DOC20/637865
MP06_0104-Mod-1

Hitchcock Road Sand Extraction and Rehabilitation Project, Maroota

I refer to the 21 July 2020 request for advice from the Environment, Energy and Science Group (EES) on the modification application for the above.

| | Page |
|--|-----------|
| Figure 2 Proposed Biodiversity Offset and Rehabilitation Strategy | 8 |

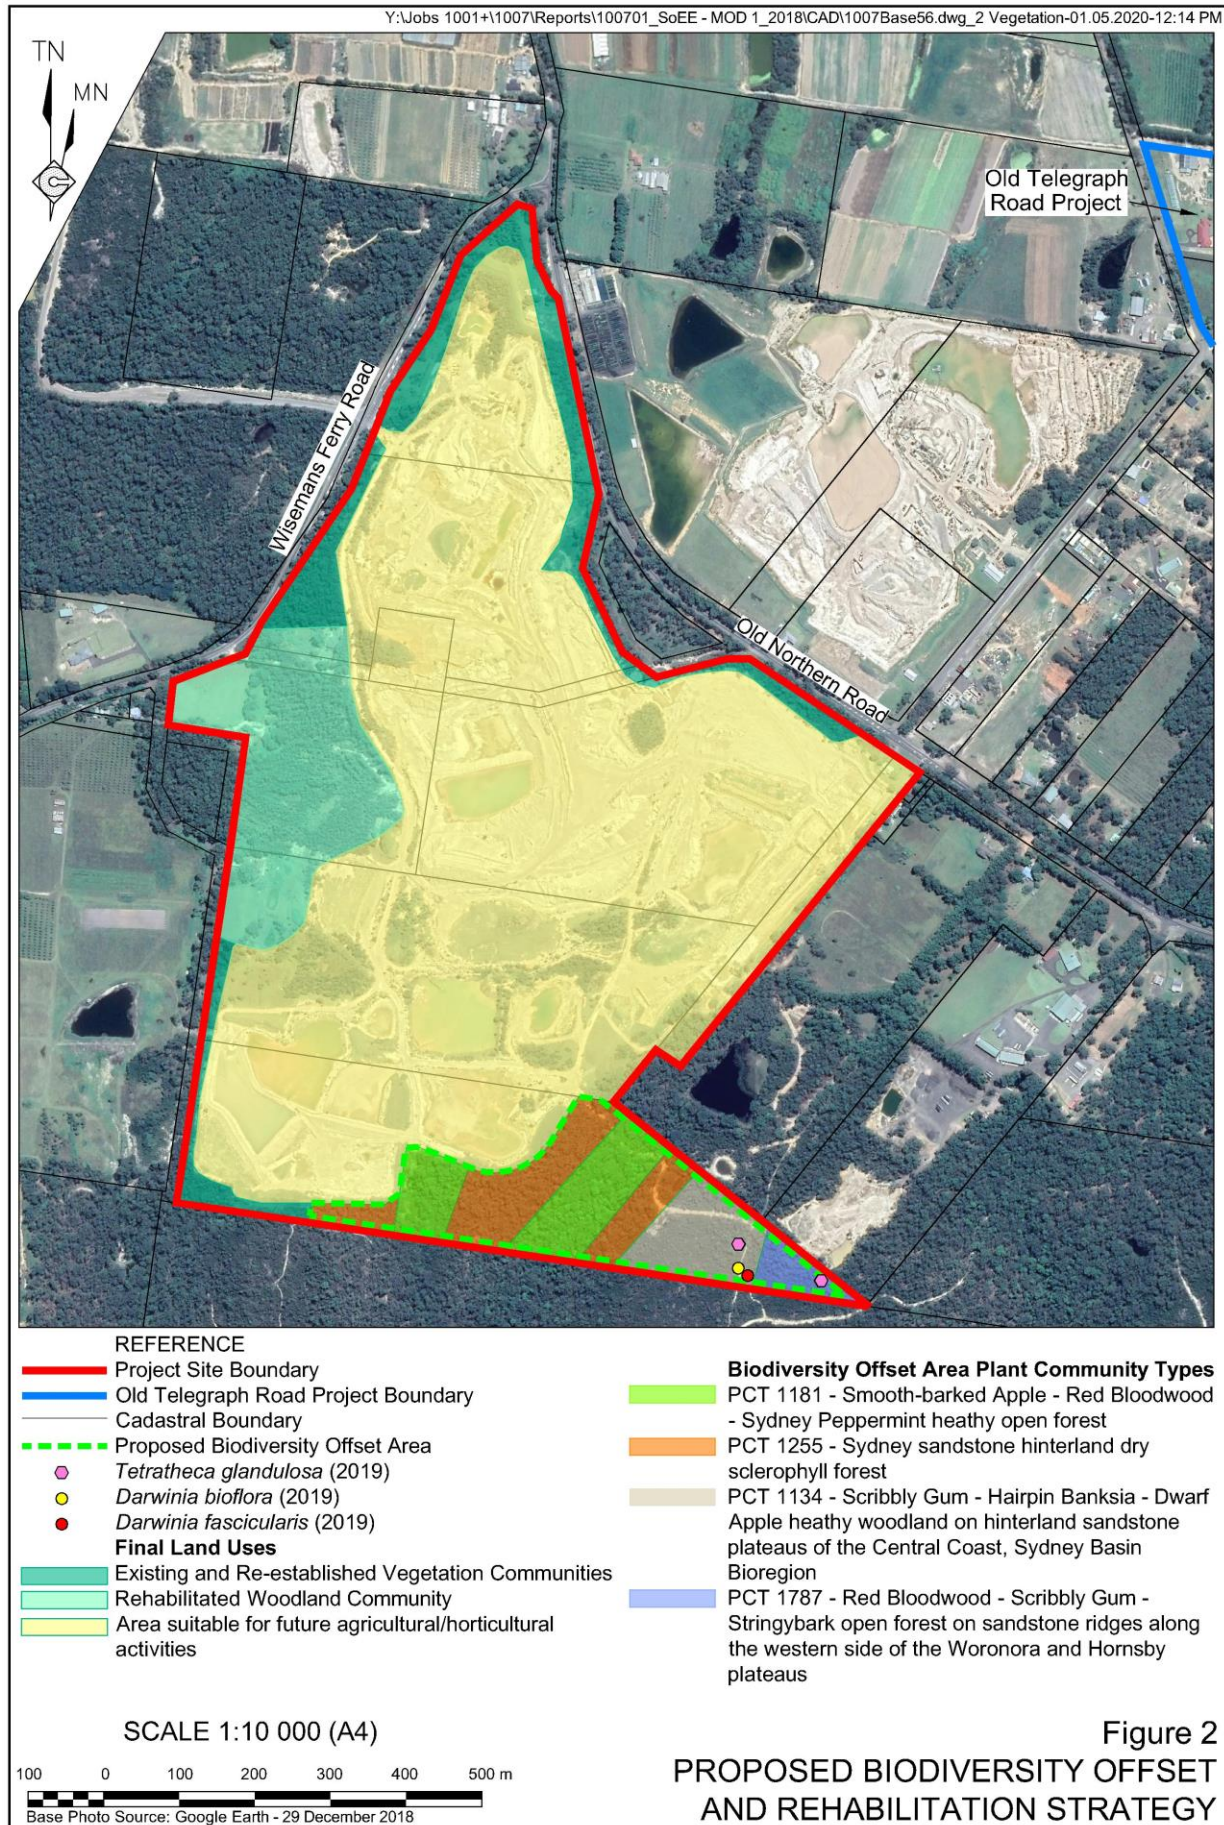
¹ EES notes the revised BOS does not confirm the SoEE advice on page 7 that an additional 3.1 ha of mined land will be rehabilitated resulting in a total of 7.3 ha of rehabilitated mined land. It is recommended this matter be clarified.
